BOTLEY WEST SOLAR FARM
OXFORDSHIRE HOST AUTHORITIES
RESPONSES FOR
DEADLINE 6 | MONDAY 20 OCTOBER 2025

Botley West Solar Farm (EN01014)

RESPONSES FOR DEADLINE 6

Client	PVDP			
Project	Botley West Solar Farm			
Title	Location of Bat Hedgerow Buffers			
Status	Drawn By	PM/Checked By		
Final	LP	NB		
Drawing Number	Scale @ A3	Date Created		
EN010147/APP/xx	1:18,000	20/10/2025		
Figure Number	Rev			
2.1	04

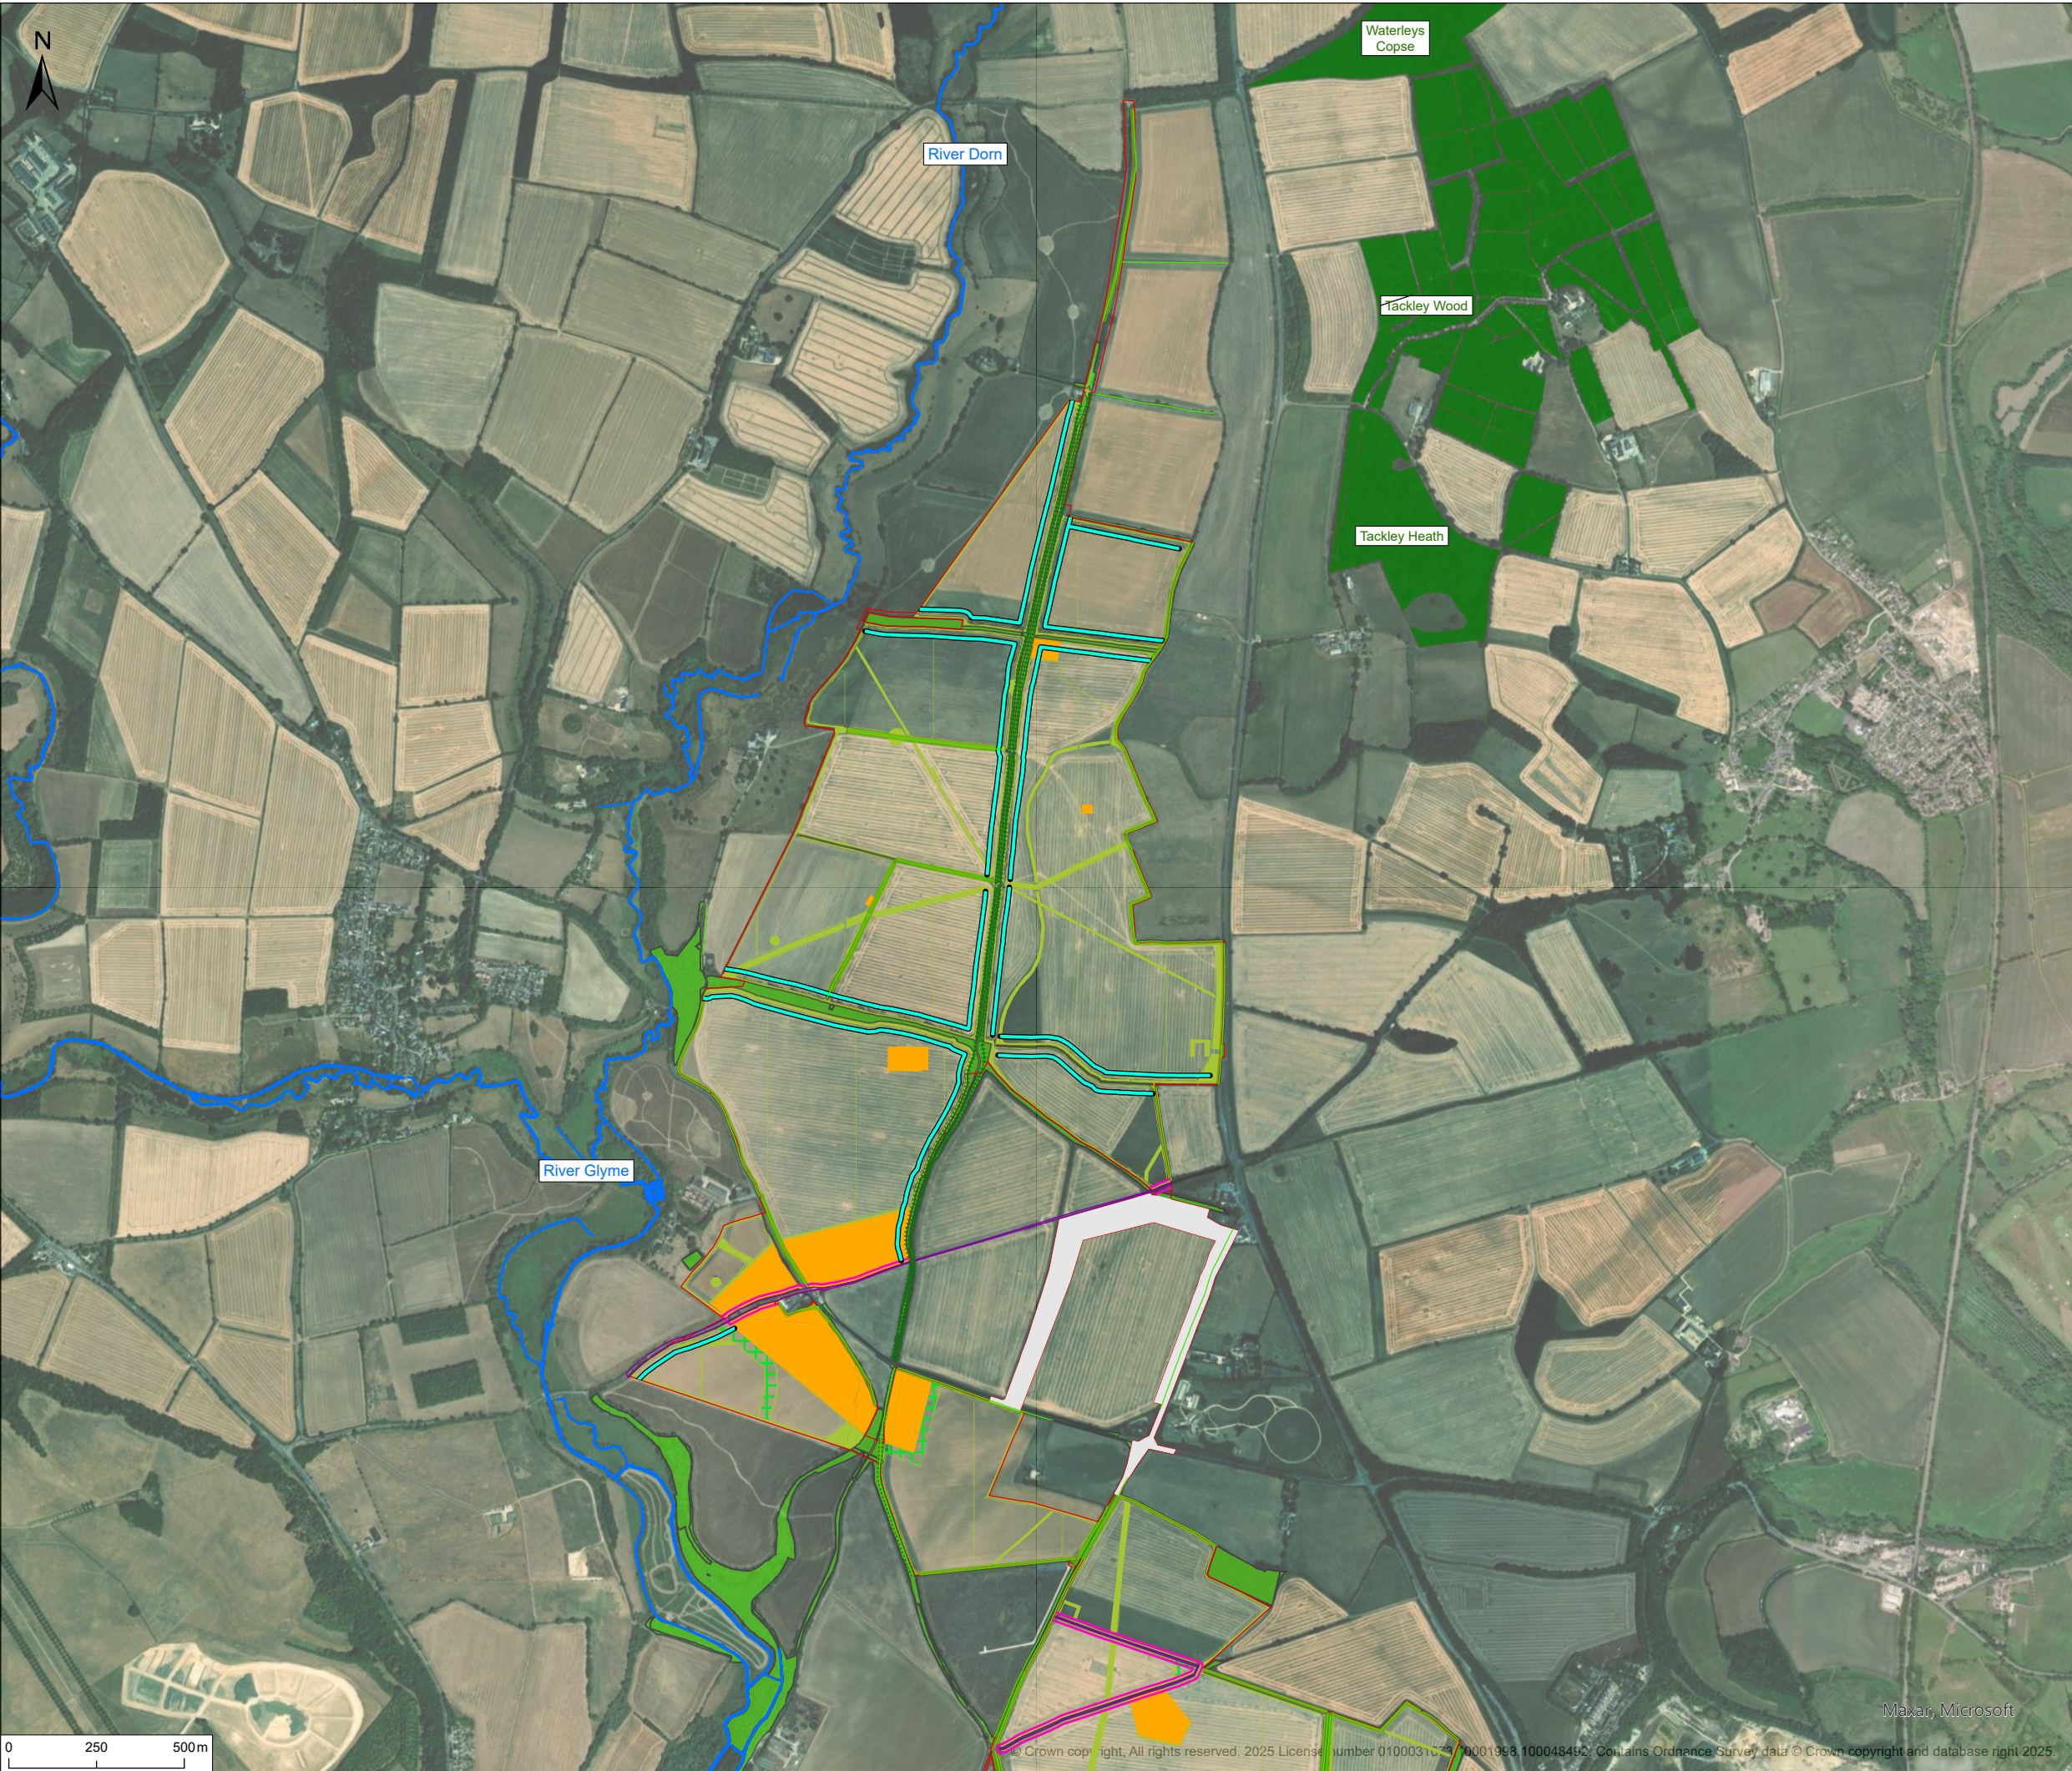
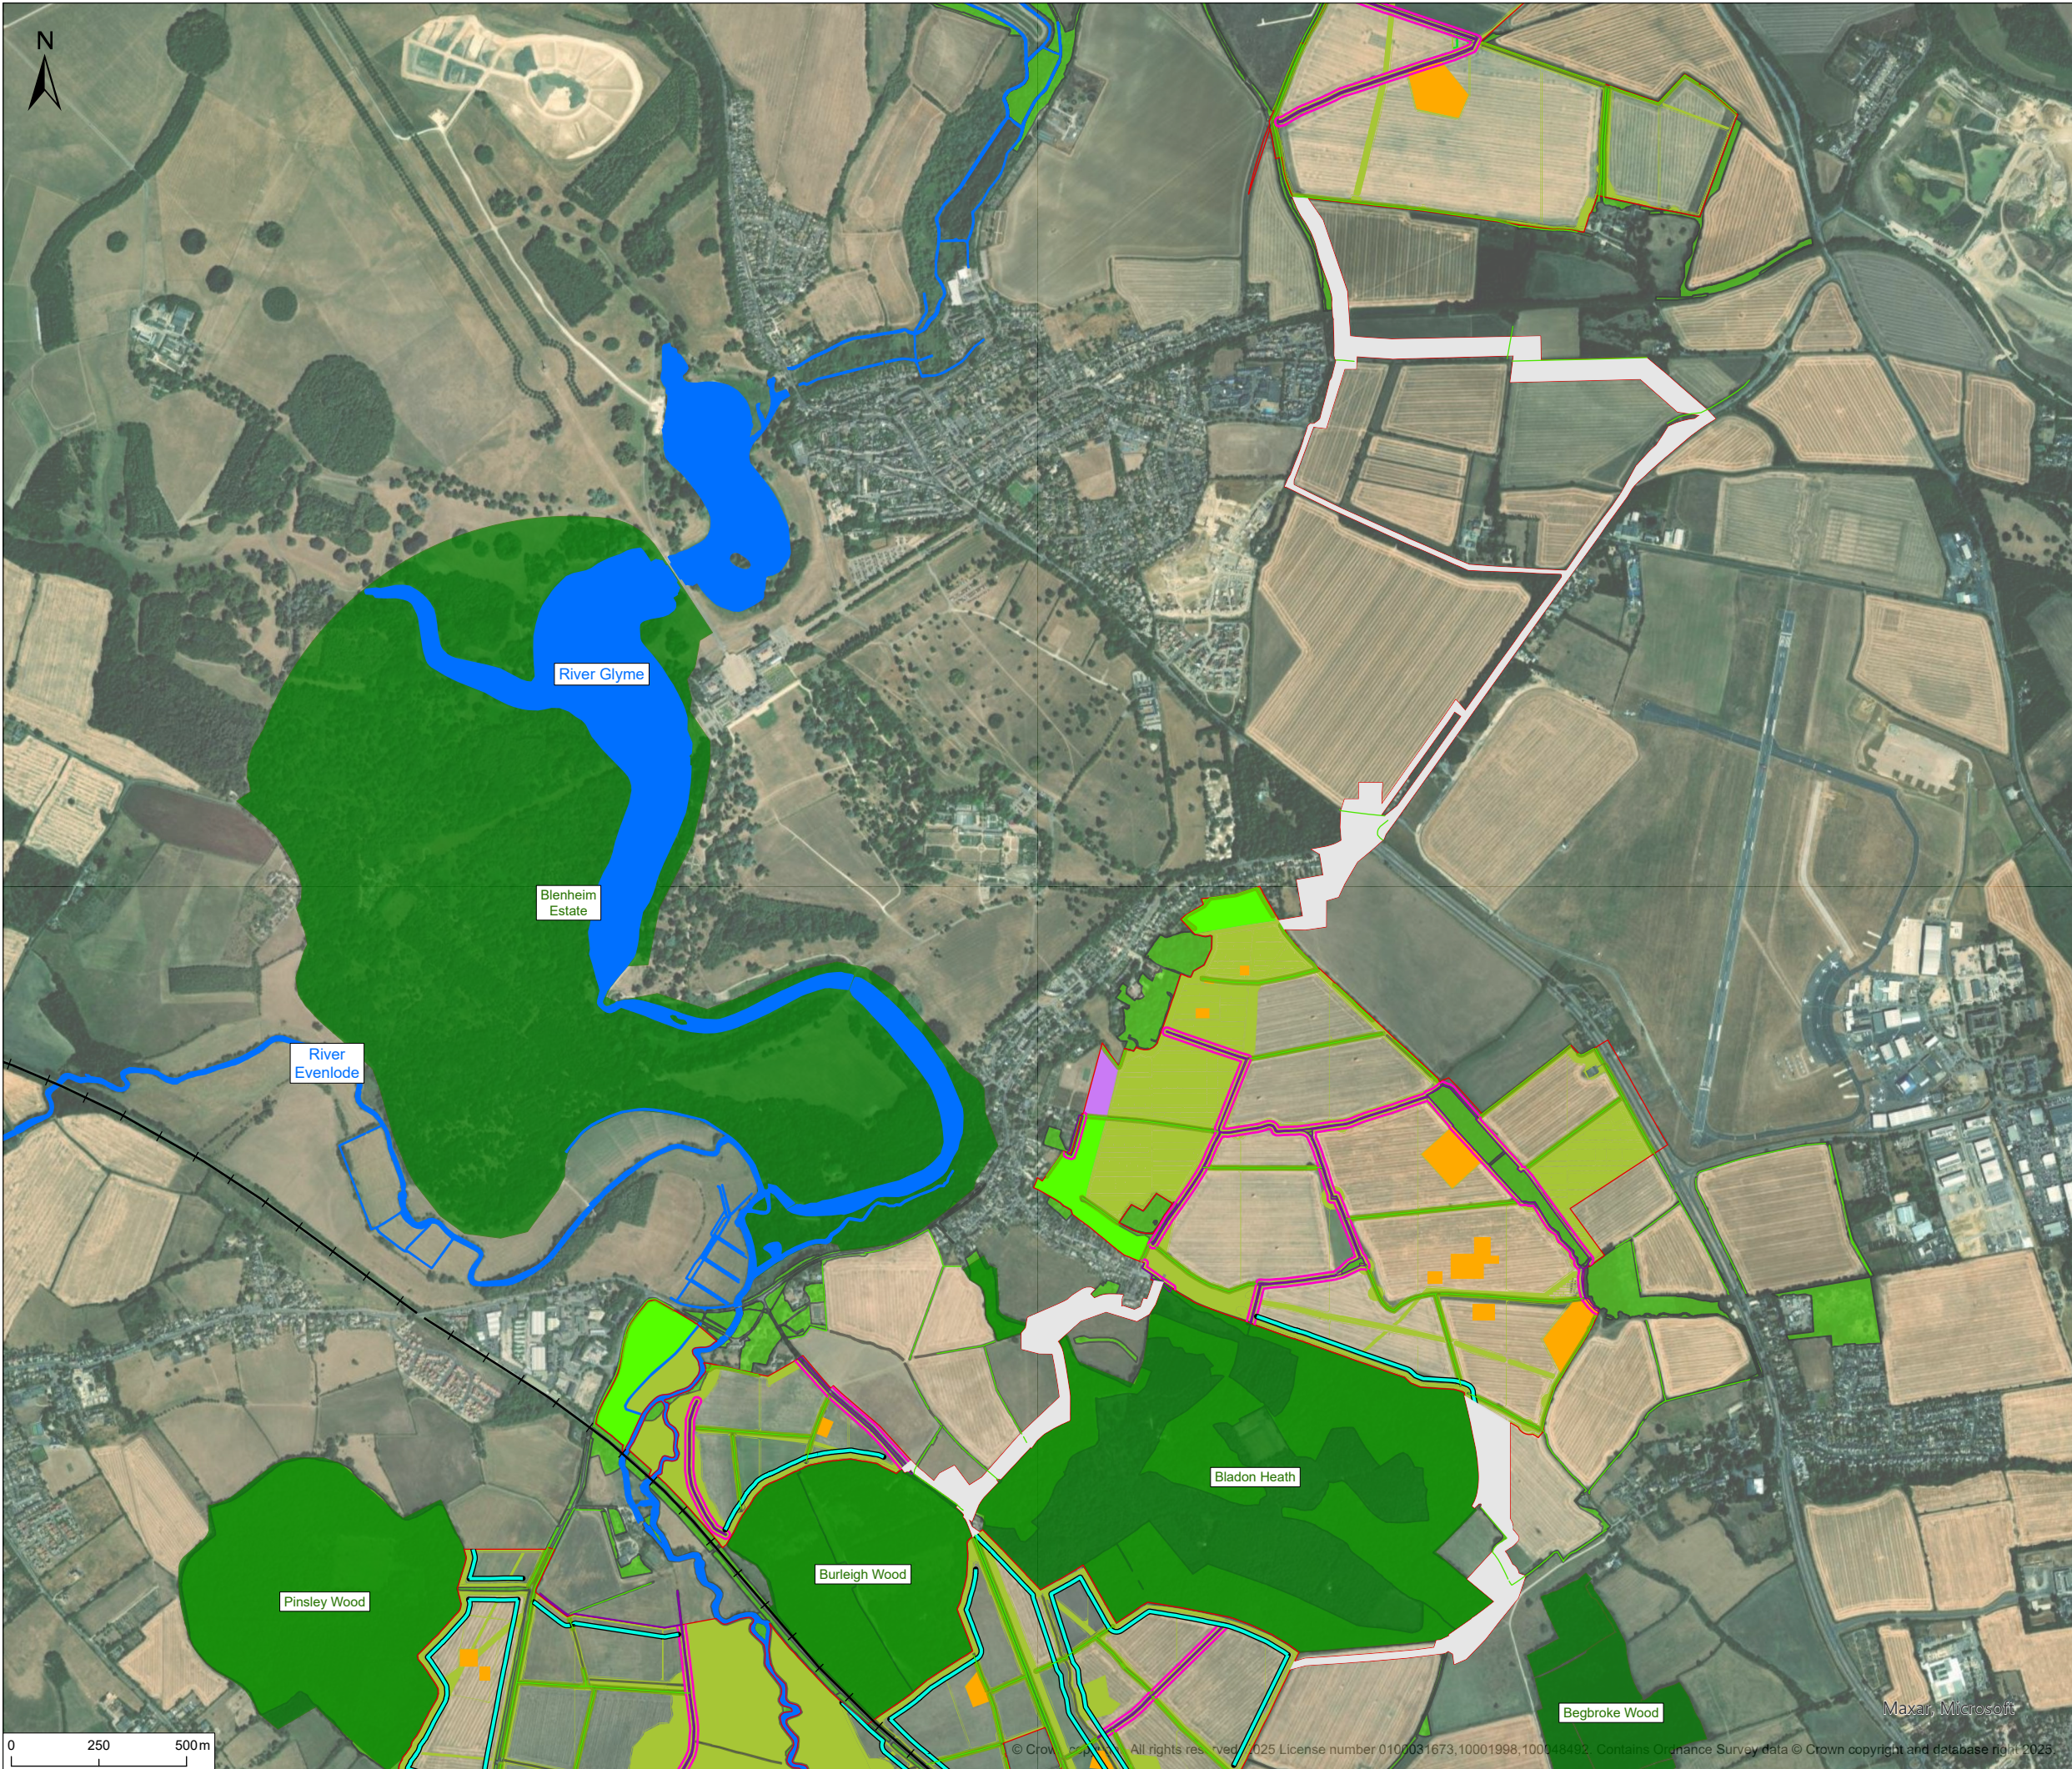
The proposal for a 3-tiered system of buffers alongside hedgerows and woodlands is welcomed, and we agree that the specifications and locations for all Tier A buffers must be confirmed before approval. We request that the locations of all Tier A flight paths must be clearly identified on a set of plans for clarity and agreement and adopted as part of the DCO. Although a list is described in Section 8.5.2 of the oLEMP and Section 8.5.3 states that *“given the importance of the Tier A buffers to the bat ecology within the landscape, the location of these will be fixed at this stage to ensure their location is secured by virtue of their inclusion within this oLEMP”*, we cannot currently see these on a map of the site and no specification is provided for the length or area. Further details therefore must be provided.
